Office of
Environment
& Heritage

DOC17/437565
SSI 8285

Notice of Exhibition - Parramatta Light Rail Stage 1 (SSI 8285)

ATTACHMENT 1 – Office of Environment and Heritage comments on Parramatta Light Rail Stage 1 (SSI 8285)

0 100 200 300 400 500
m

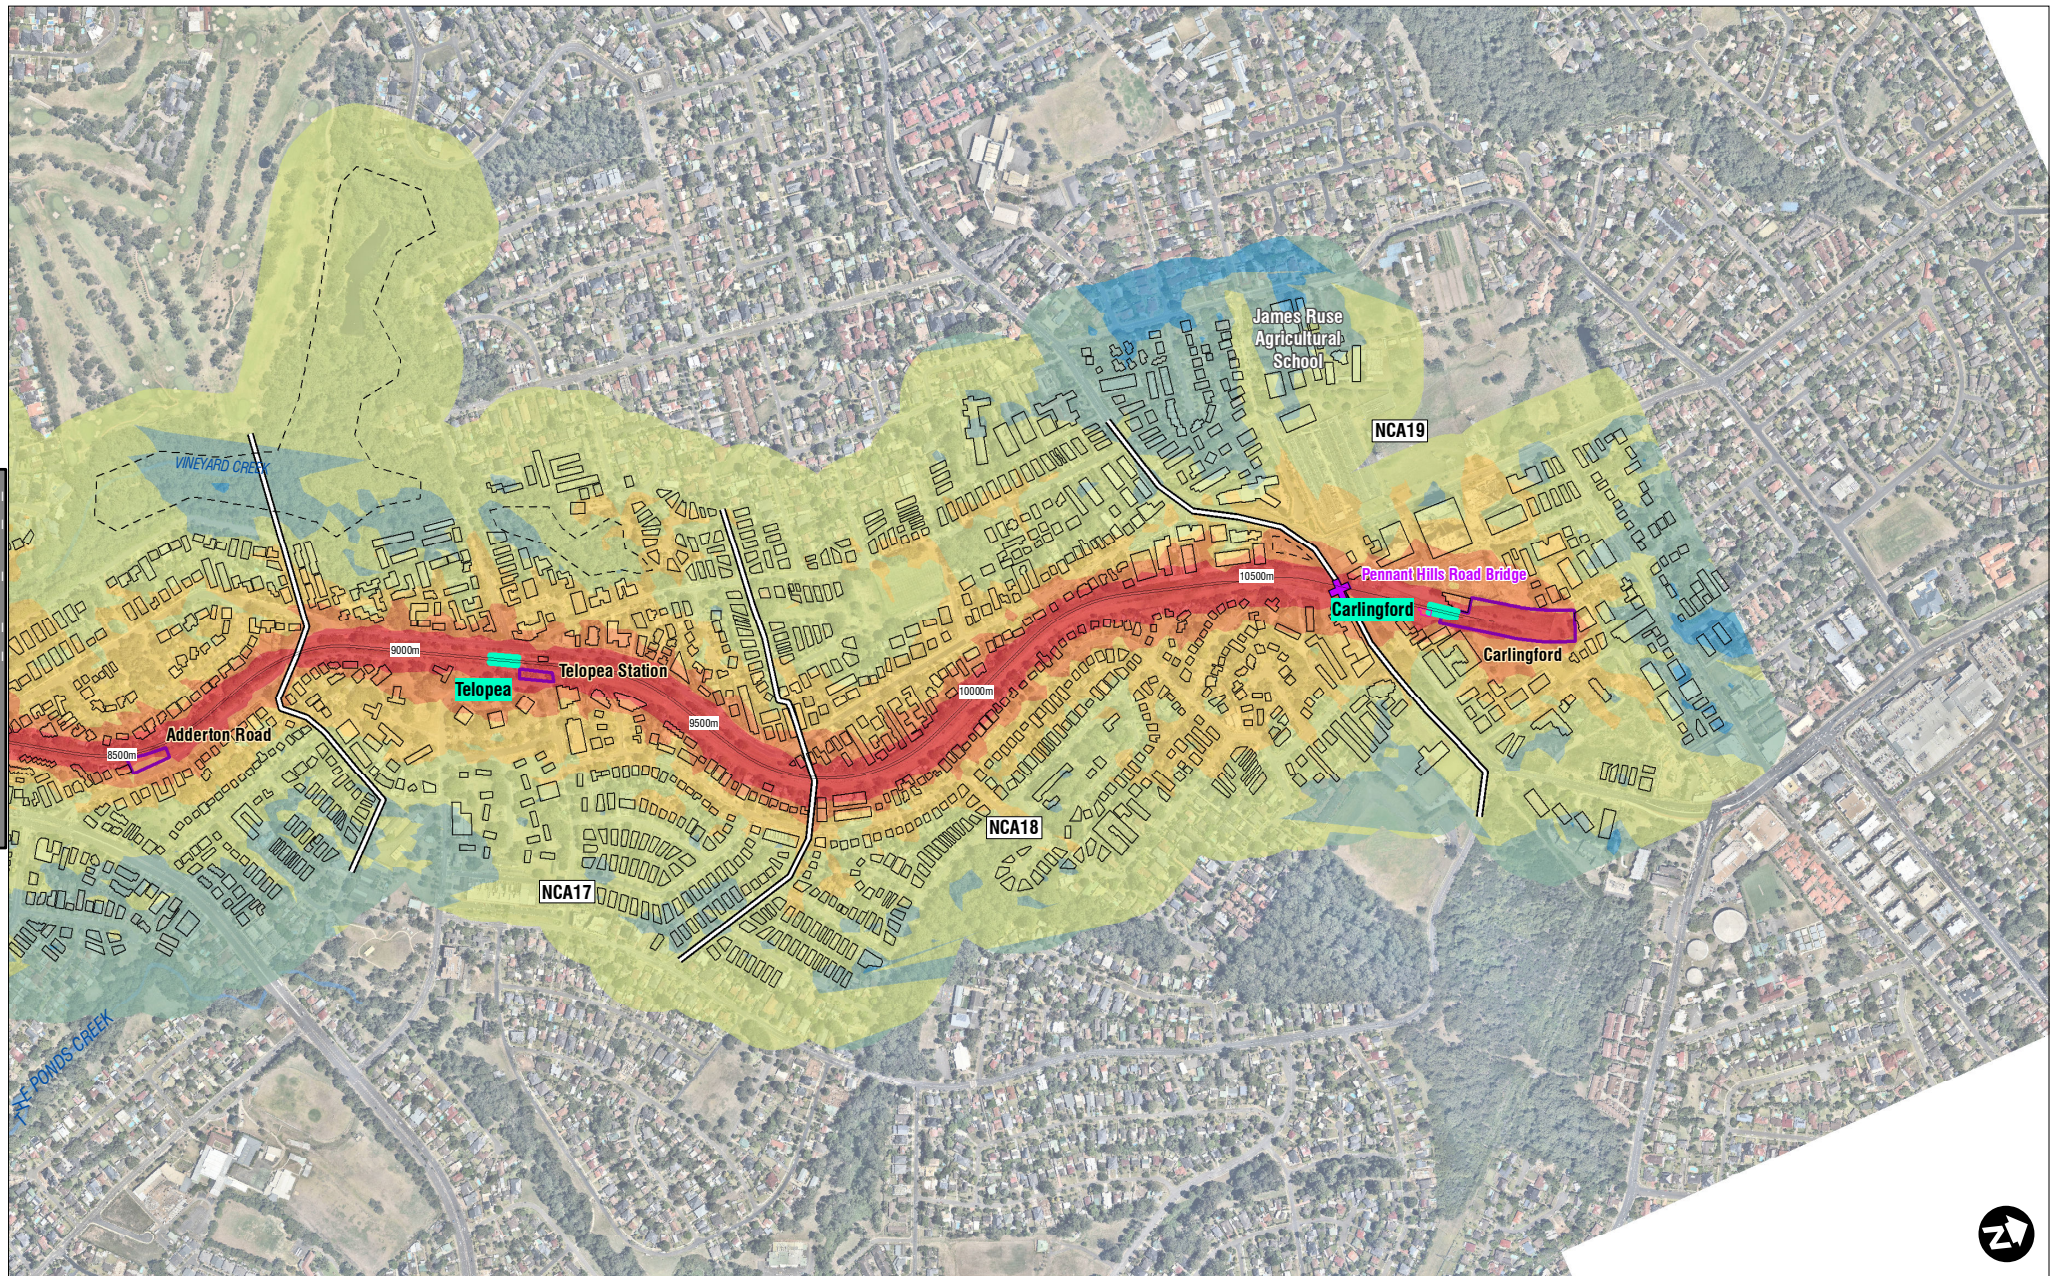
The BAR states that GHFF are tolerant of some level of ongoing noise and light impacts, which OEH agrees with. However, it is the impacts from construction noise associated with this proposal that OEH considers are of most concern. The BAR mentions construction noise impacts in Section 8.6.1.2, but the BAR concludes that these will not be an issue as the noise will be adequately buffered by vegetation and buildings. OEH notes that the Noise and Vibration Impact Assessment prepared by SLR Consulting does not include objective measurement of potential noise that could reach the camp.

The BAR also states that "Although noise from the Bridge Street bridge area of the construction boundary may reach the camp more directly, the highest noise levels are considered unlikely to reach levels for extended periods that other GHFF camps are accustomed to at the nearby Clyde camp or those at Singleton and Balgowlah." OEH does not consider this a fair comparison, as the GHFF camps at Clyde, Singleton and Balgowlah are not accustomed to the very loud, sometimes sudden types of noise related to construction, they are accustomed to the lower, more predictable operational noises. In fact, there is anecdotal evidence that the Clyde camp, as well as other camp sites (e.g. Kurnell) did temporarily disperse because of noise from adjacent construction projects. Therefore, OEH considers that given the high risk that the construction noise impacts could disperse or move the camp to a less suitable location, that the BAR should include a more thorough noise assessment, which quantifies potential impacts and demonstrates, through comparisons with other similar situations and projects, that the GHFF will not be impacted by this noise.

Section 8.6.1.6 of the BAR states that a biodiversity management plan will be prepared for the project to manage the natural environment during the construction phase of the project, which will include strategies to minimise impacts on the GHFF camp at Parramatta Park. OEH supports this but considers that the biodiversity management plan should also include contingency measures that will be undertaken if the mitigation measures have been unsuccessful in mitigating impacts, i.e. if the camp disperses or shifts location as a result of the works. It is noted that the Parramatta Park camp has shifted recently, which is likely due to construction noise associated with the Parramatta North Urban Transformation site and Western Sydney Stadium.
